1st February 2008

Our reference: SWB/BE/0001/08 OUT

Town and Country Planning Act 1990
Formal Strategic Consultation under Schedule 1, Paragraph 7(2)

Outline application for mixed use employment (Class B1 high quality business park comprising up to 19,500 sq m gross floorspace) and retail (Class A1 grocery store up to 4,459 sq m net sales area) together with parking, new highway & associated servicing, infrastructure & landscaping. Land at Oldlands Farm, Shripney Road, Bognor Regis.

6.2 Landscape Master Plan

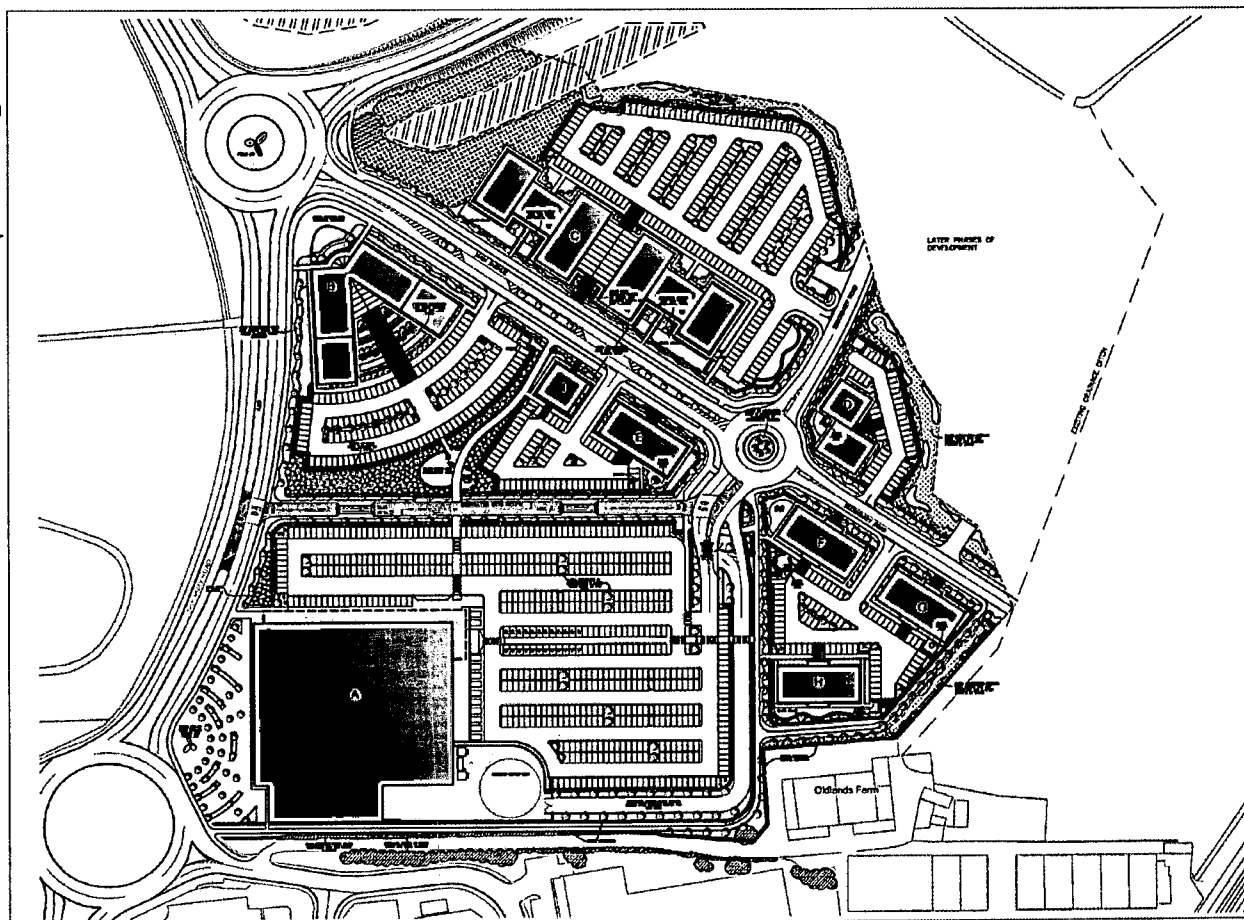
Although the landscape design is in outline, the suggestion is that very few species are used; e.g. mass planting of birch groves and fastigate oak avenues. This is not supported, and it is considered that the site would benefit from a wider range of native species, which would enhance the sustainability of the site whilst also fulfilling the design approach. There is no strategy for integrating the new site into the existing landscape, this aspect is absent from the Design and Access Statement and no reference is made to the need for it. Again, this is considered an important part of the design approach given the site's proximity to Shripney village and its context in the wider Chichester Coastal Plain Character Area.

The location of public art – given the examples stated - immediately on the rural fringe is likely to impact significantly on the transition from rural to urban landscape. The avenue planting which is stressed in the report seems quite sparse (trees planted too far apart) and it is hoped that a revised scheme would accommodate greater numbers of more densely planted trees. The eastern boundary of the site has no landscape treatment shown. The staggered avenue of trees along the car park access road to the south seems to be rather sparse; planting more trees closer together would lead to an improvement. The hedge along the southern boundary –it is stated that it would be gapped up – when in fact it could be increased in width as desired and linked into green corridors within the site and beyond.
